22 May 2017

Roads and Maritime Reference: SYD16/00353/02  
DP&E Ref: SSD 7543

**NORTH SHORE PRIVATE HOSPITAL 12 FREDERICK STREET, ST LEONARDS (SSD 7543)  
NOTICE OF EXHIBITION**

12 FREDERICK STREET, ST LEONARDS
LG1 CAR PARK
SWEPT PATH ASSESSMENT

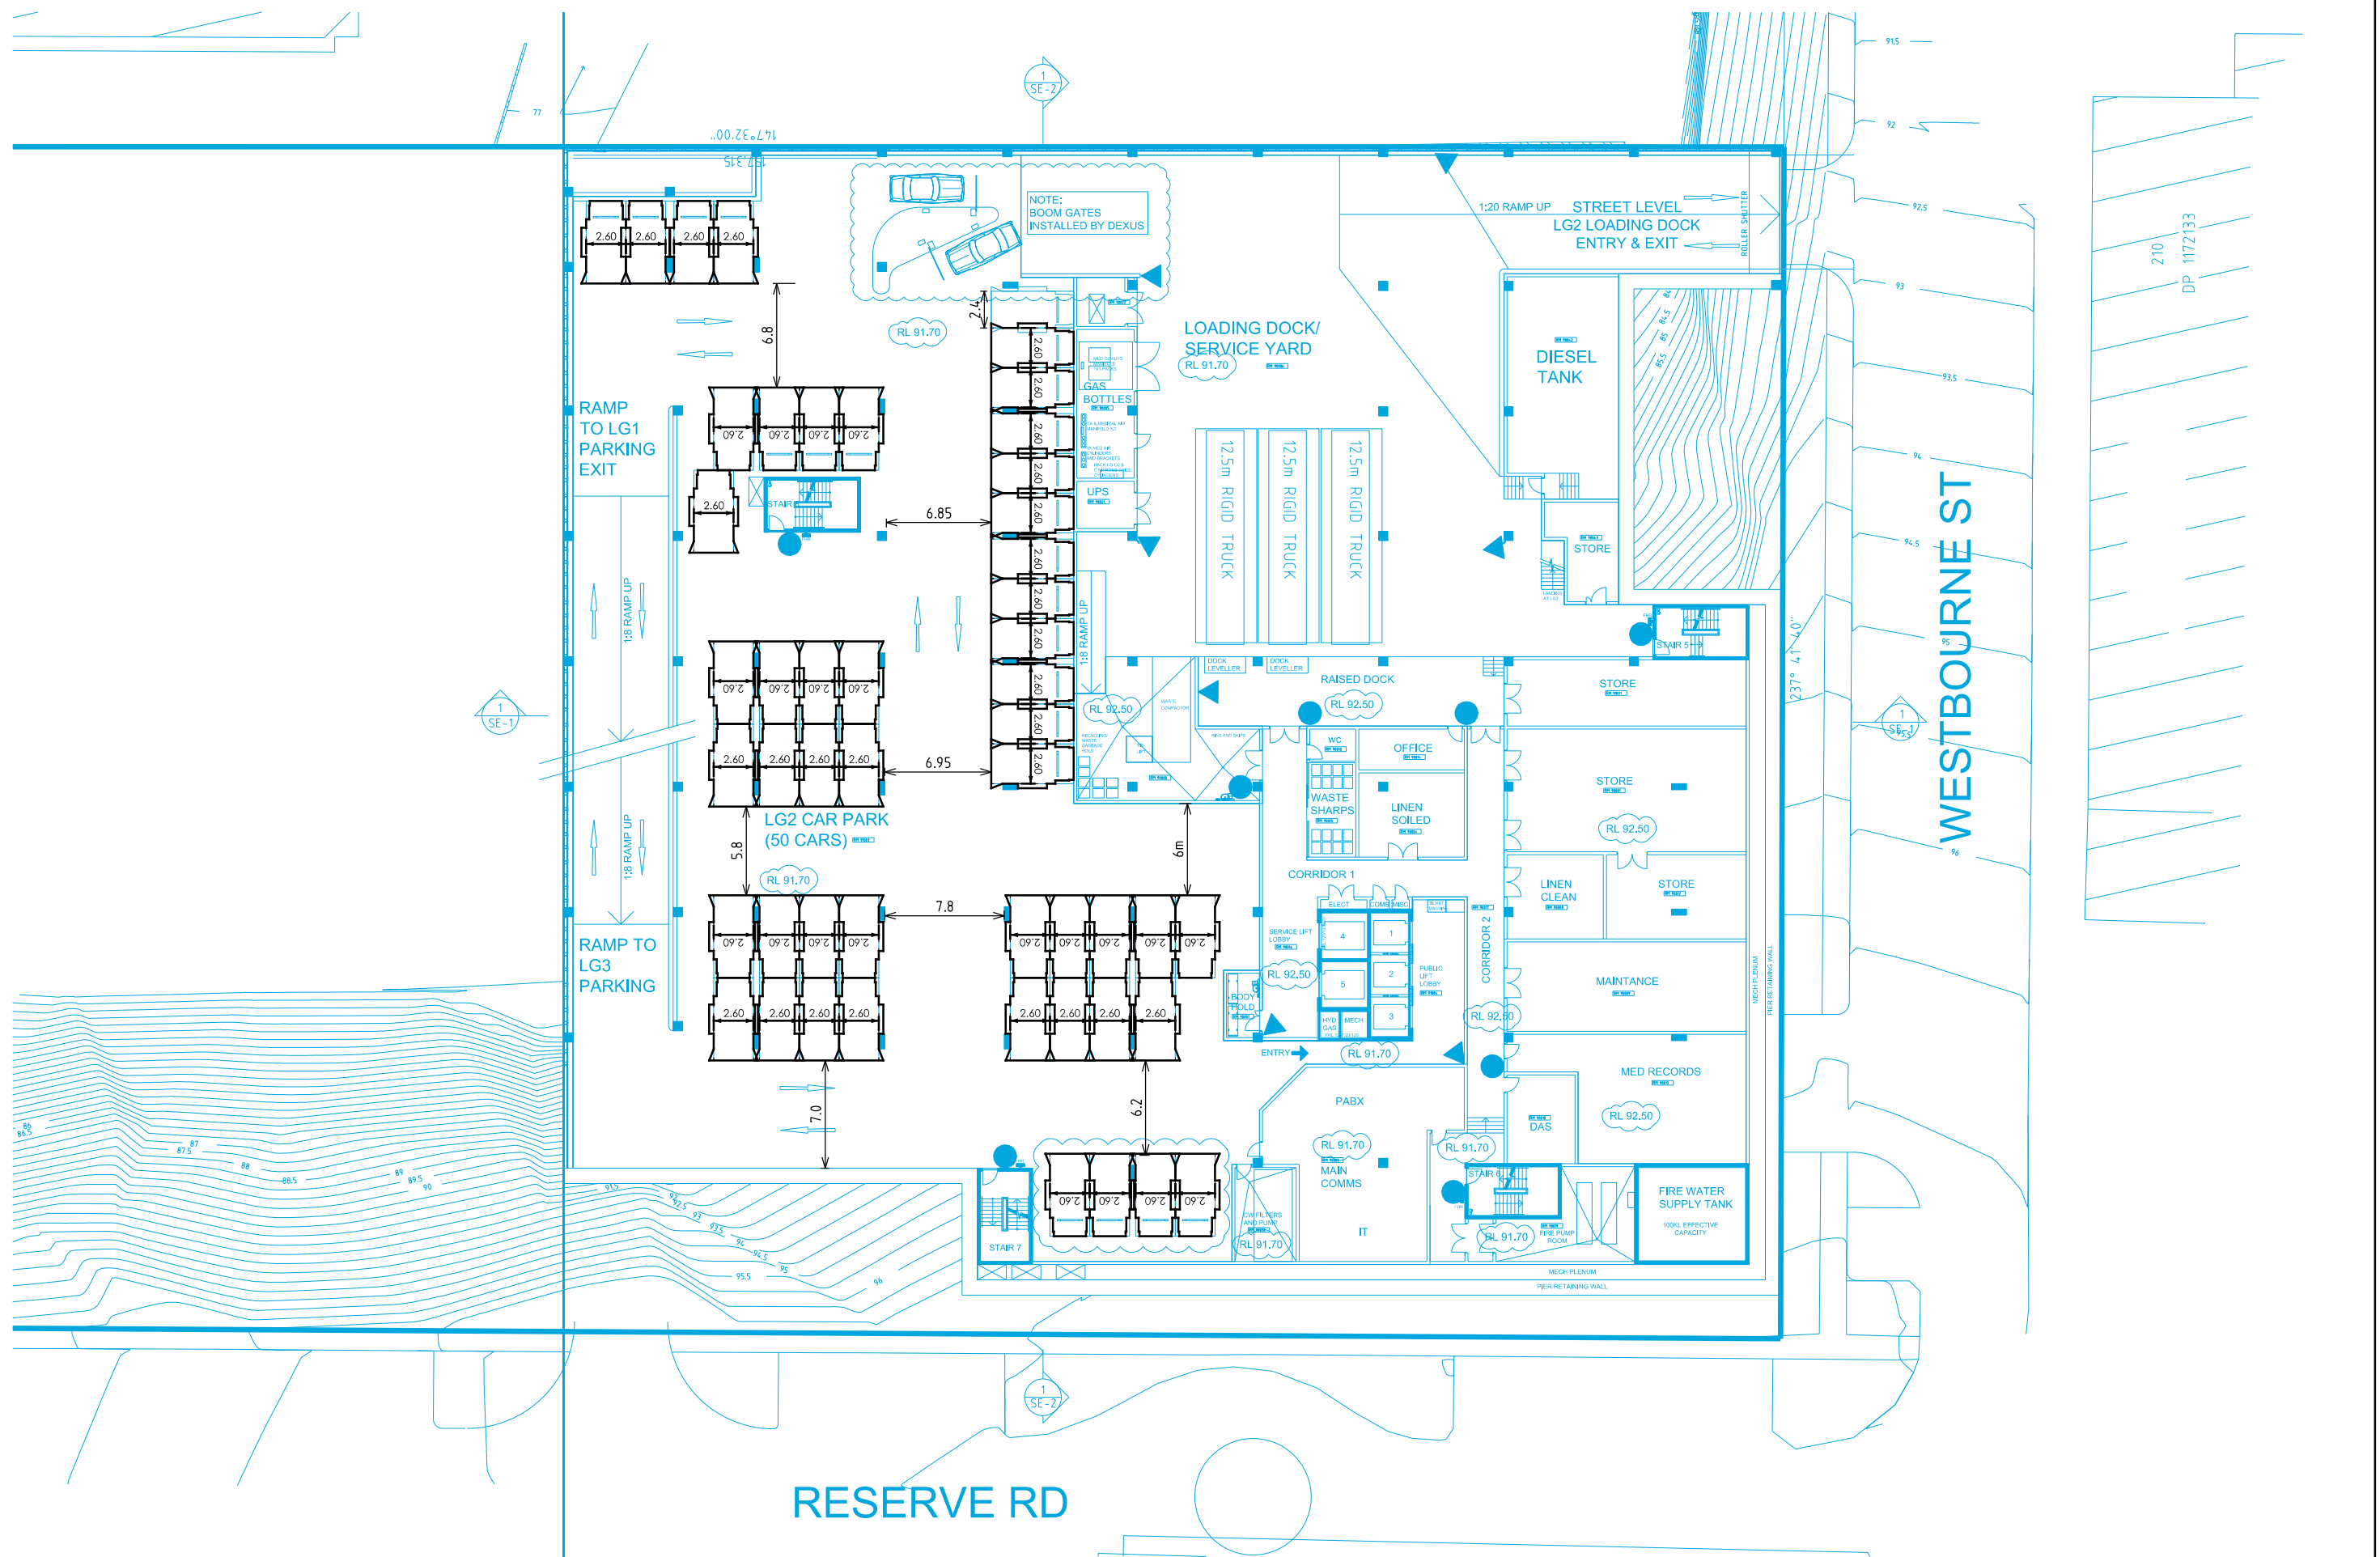
1. The layout of the proposed car parking areas associated with the subject development (including, driveways, grades, turn paths, sight distance requirements in relation to landscaping and/or fencing, aisle widths, aisle lengths, and parking bay dimensions) should be in accordance with AS 2890.1- 2004, AS2890.6-2009 and AS 2890.2 – 2002 for heavy vehicle usage. Parking Restrictions may be required to maintain the required sight distances at the driveway;
2. Sight distances from the proposed vehicular crossings to vehicles on Frederick Street are to be in accordance with the Austroads 'Guide to Traffic Engineering Practice, Part 5: Intersections at Grade, Section 6.2 – Sight Distance' and AS 2890. Vegetation and proposed landscaping/fencing must not hinder sight lines to and from the vehicular crossings to motorists, pedestrians and cyclists;
